First floor side extension, loft conversion with rear dormer, rear canopy, and extension to detached garage. This application affects the character and appearance of Aldwick Bay Conservation Area
229 Manor Way Aldwick

Thank you for your internet representation made on 14th November 2018 which has been recorded as '**an objection**' with the comments as follows:

Drawing Title:
EXISTING GARAGE PLANS & ELEVATIONS
PROPOSED SINGLE STORY EXTENSION TO
EXISTING GARAGE

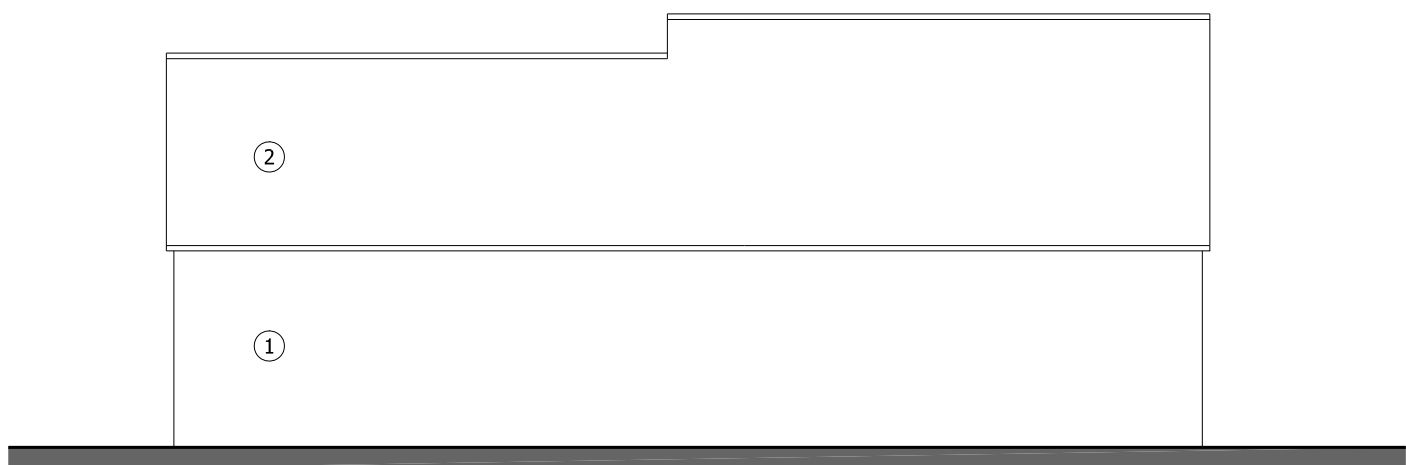
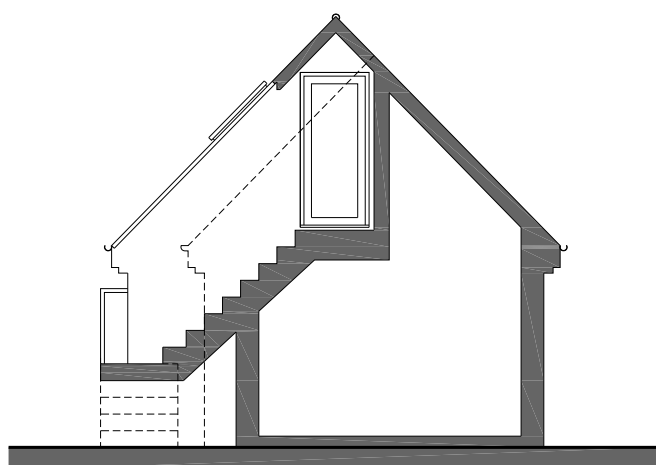
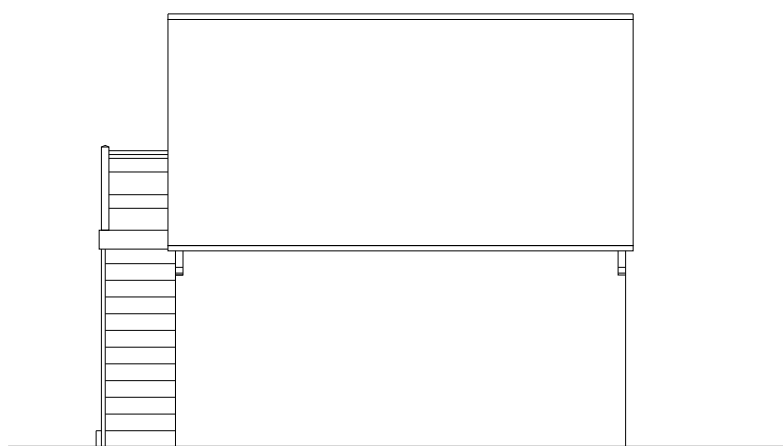
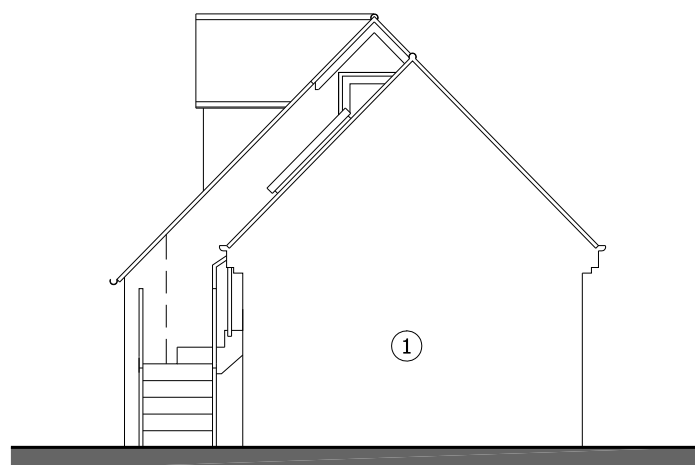
The rear canopy and the height of the extension to the rear of the existing garage is equivalent to the height of a double storey building. We find this most invasive as it will take a lot of light from our property and garden. The distance from our boundary fence to our Conservatory is only 8 metres, so the height of the apex of the roof on the extension will appear over powering.
